## TCL Letter of Response

**Date:** Thursday, March 23, 2023

**Project:** Safety Counseling (2900 Wellesley Drive, Albuquerque NM 87110)

**RE:** TCL Letter of Response

B4 REFUSE ENCLOSURE
PLAN

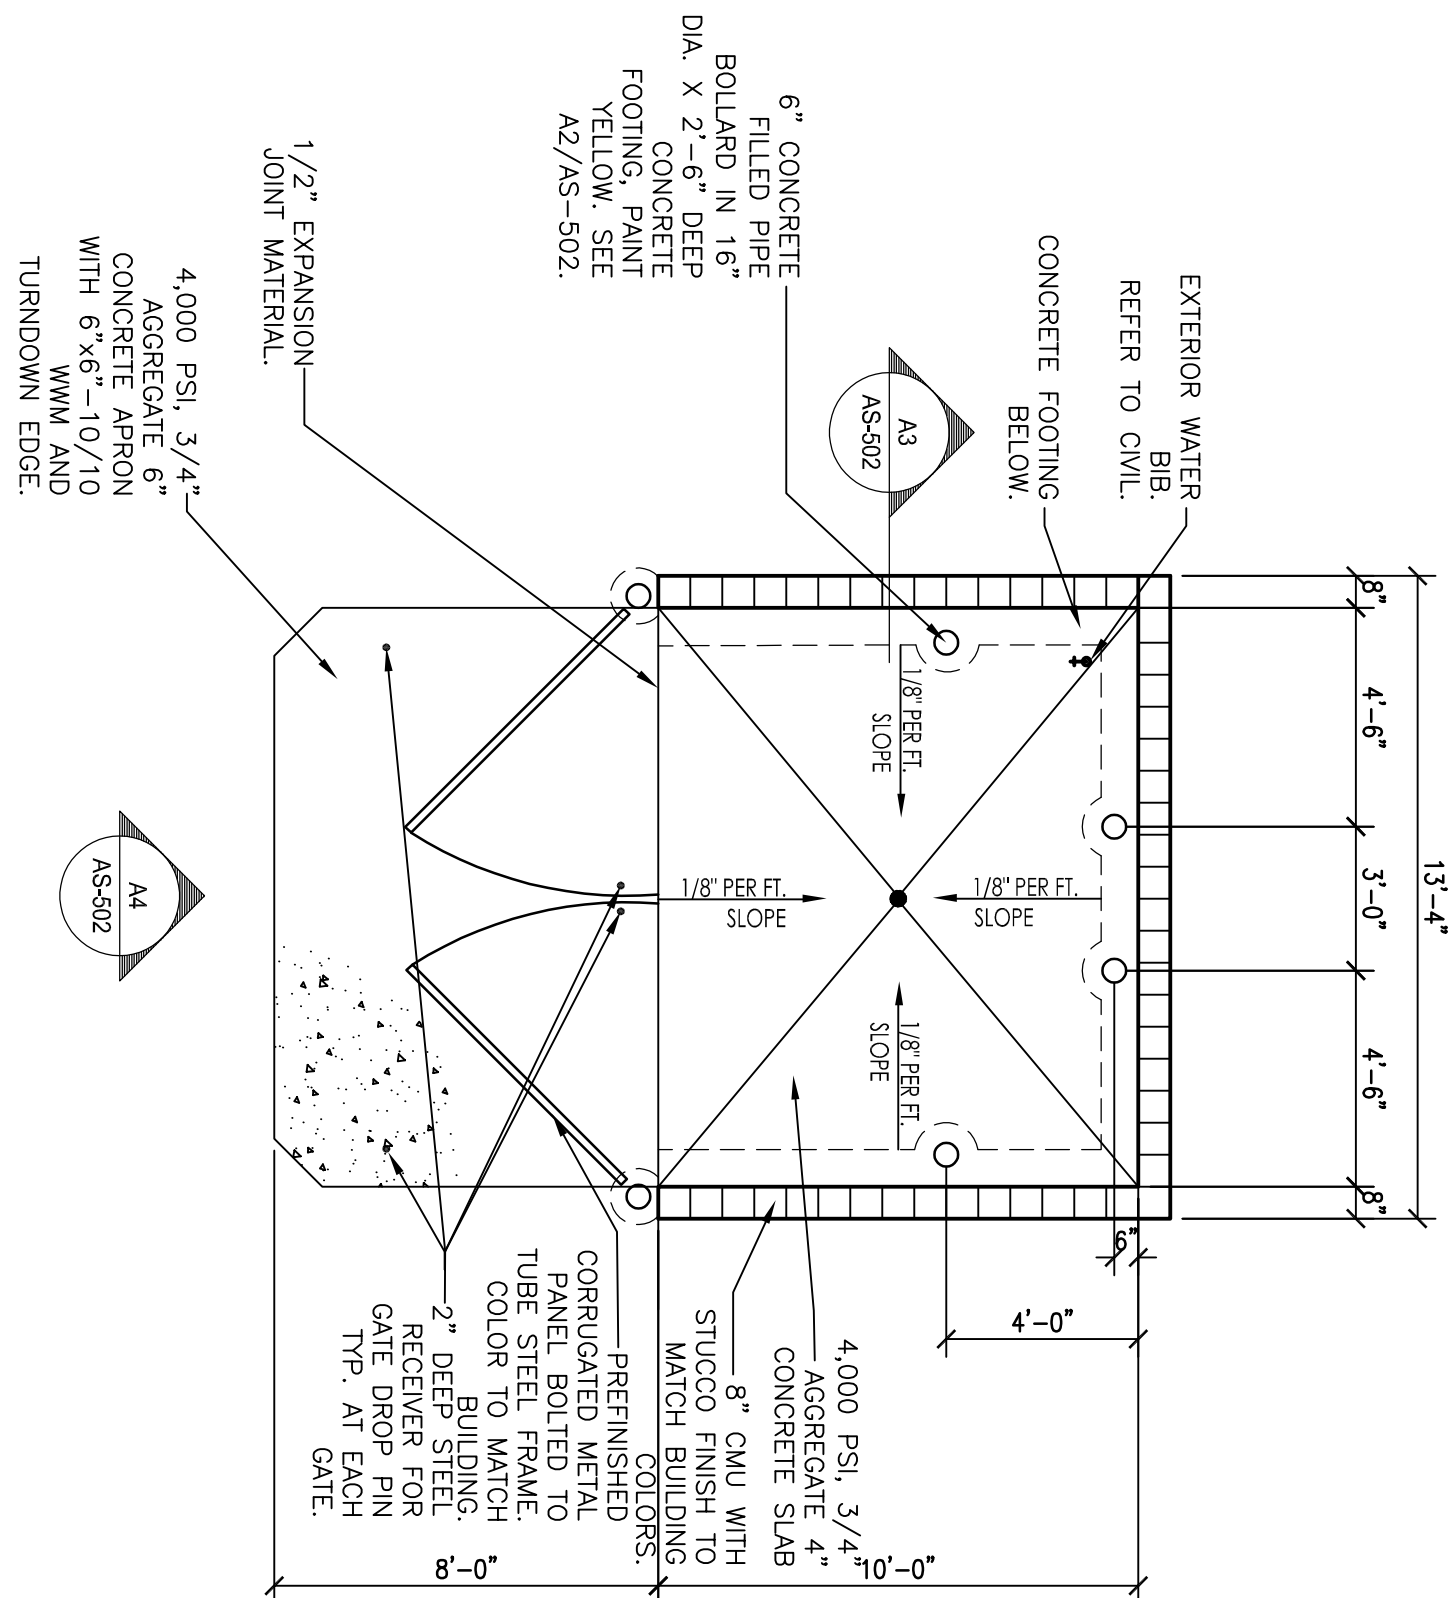
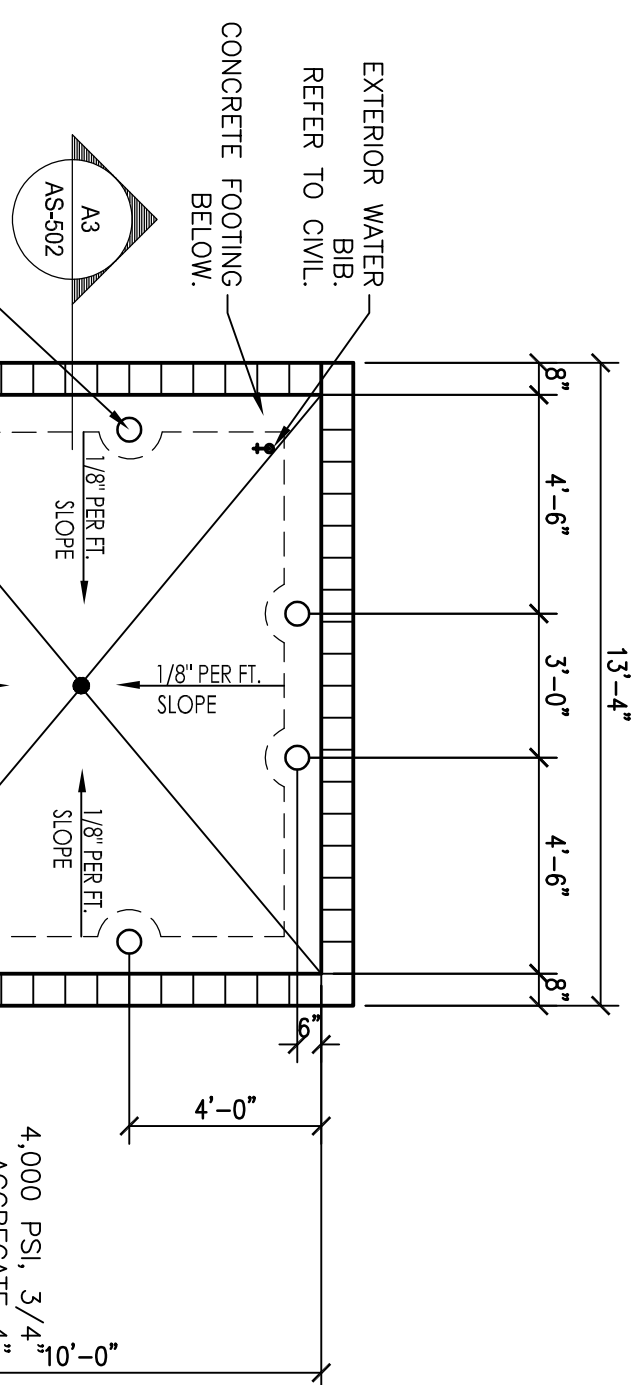
- **See general note N and keyed note #42.**
7. Refuse vehicle maneuvering shall be contained on-site. The refuse vehicle shall not back into the public right of way.; provide a copy of refuse approval.

- **See Sanitation approval dated 03/21/2023 attached.**
8. Provide a copy of Fire Marshal Approval.
  - **See Fire Marshal Approval dated 03/22/2023 attached.**

B2 HC RAMP
DETAIL

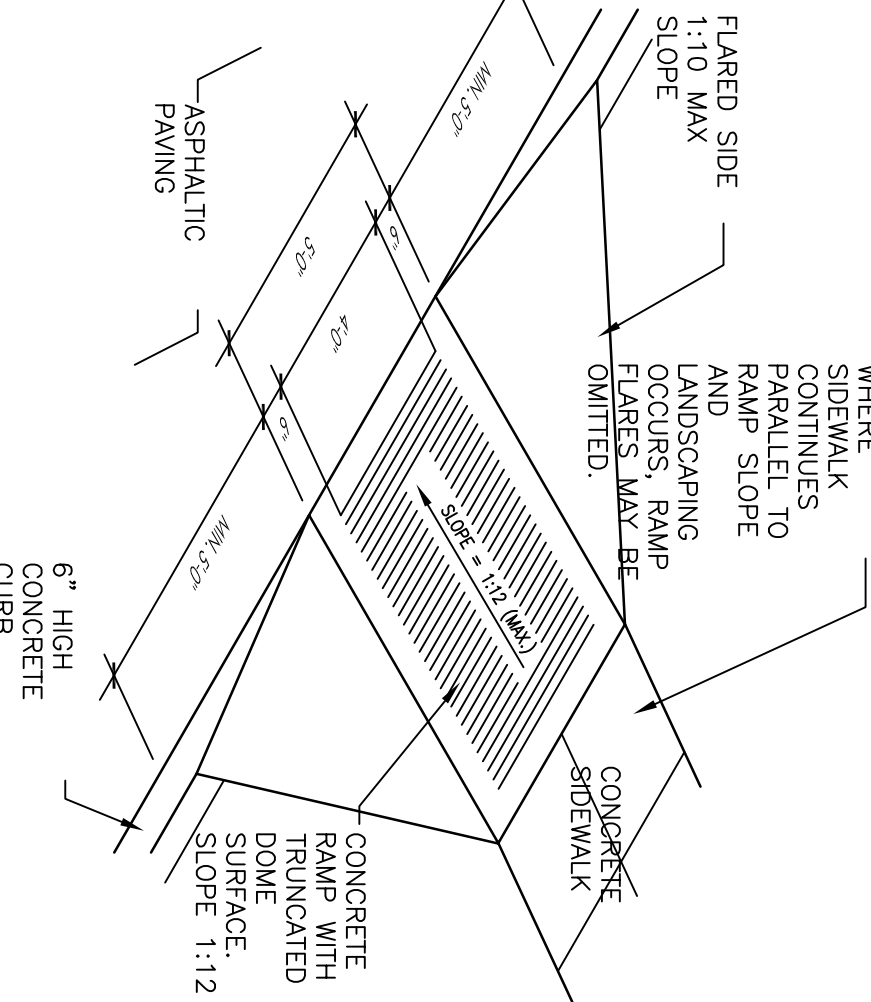
5. Keynote 31: please show on the site plan 5'X5' ADA landing area, or Suggestion: refer to COA std dwg 2443 detail A-Parallel curb ramp.
  - **Detail has been modified to reflect COA detail 2443 for A-Parallel curb ramp. See keyed note #31.**

TOPOGRAPHIC SURVEY
LOT C-2
DUKE CITY INDUSTRIAL AREA
CITY OF ALBUQUERQUE,
BERNALILLO COUNTY, NEW MEXICO
SEPTEMBER, 2022

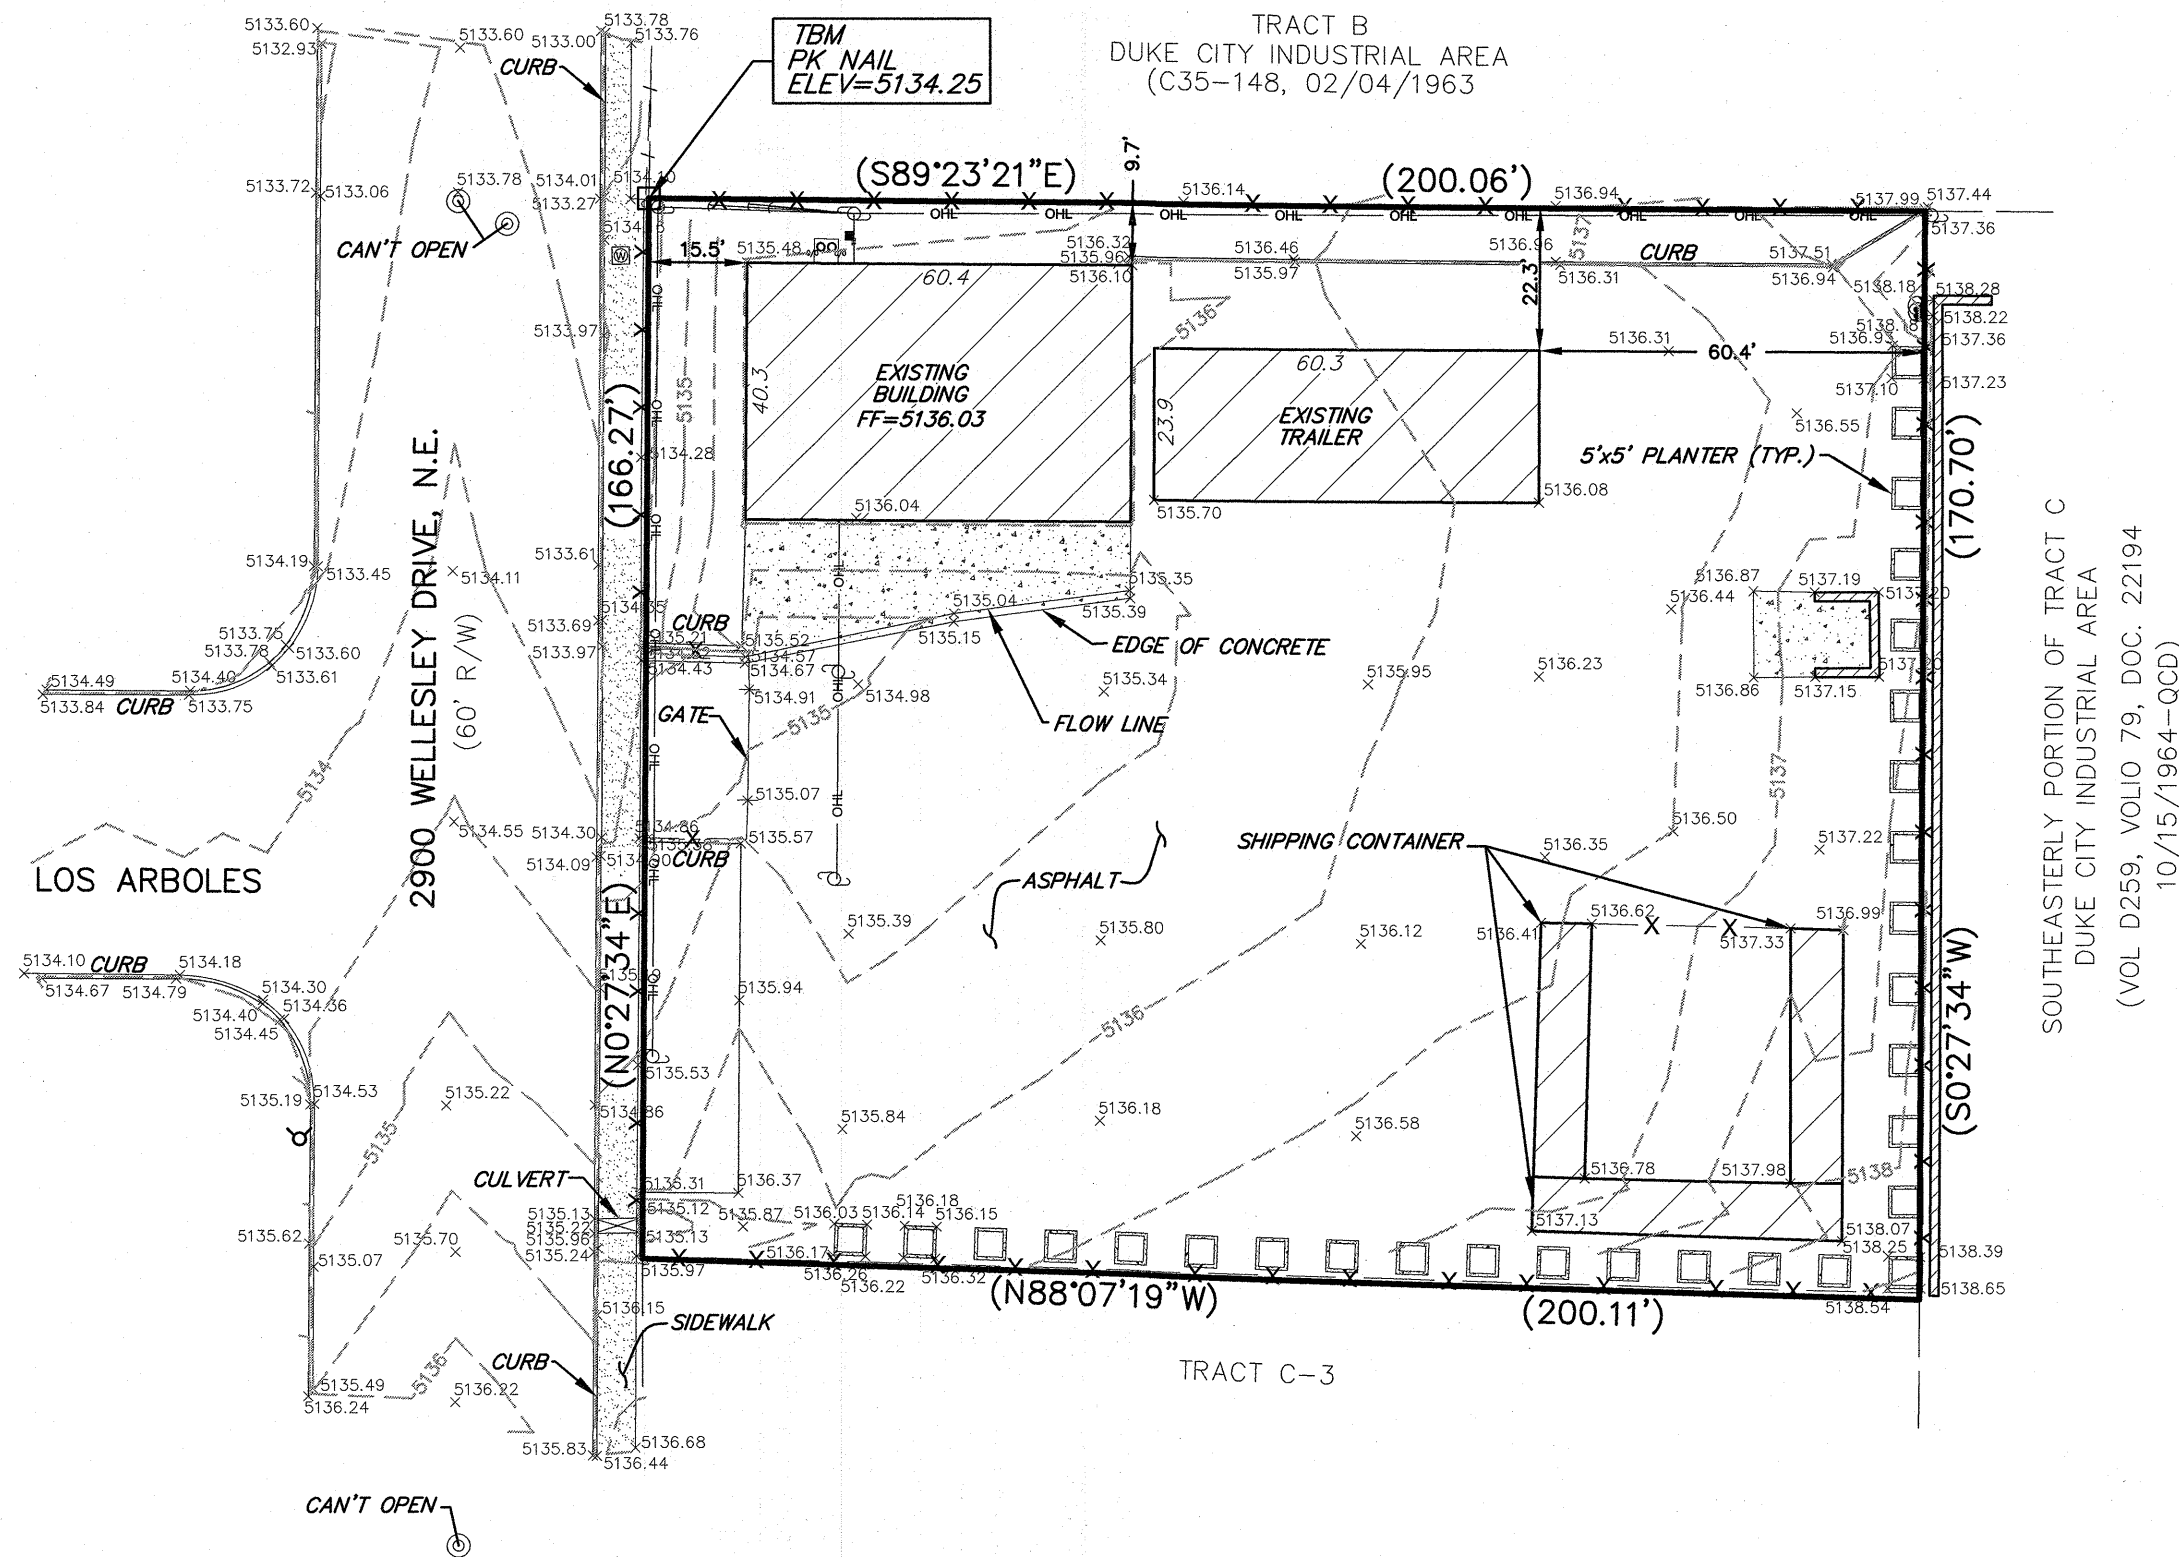
1. Identify all existing access easements.
  - **There are not currently any identifiable easements located on the property other than already identified. Please see attached survey dated 9/16/2022.**
2. Existing drivepad must be updated to current ADA standard. Please provide driveway width and design details.
  - **We have updated the drivepad to meet COA standard 2425A. See keyed note #12.**
3. Please see attached blue-marked site plan and provide the driveway width.
  - **Existing driveway width dimension has been given both at gate and open driveway as requested. 24' minimum is provided.**
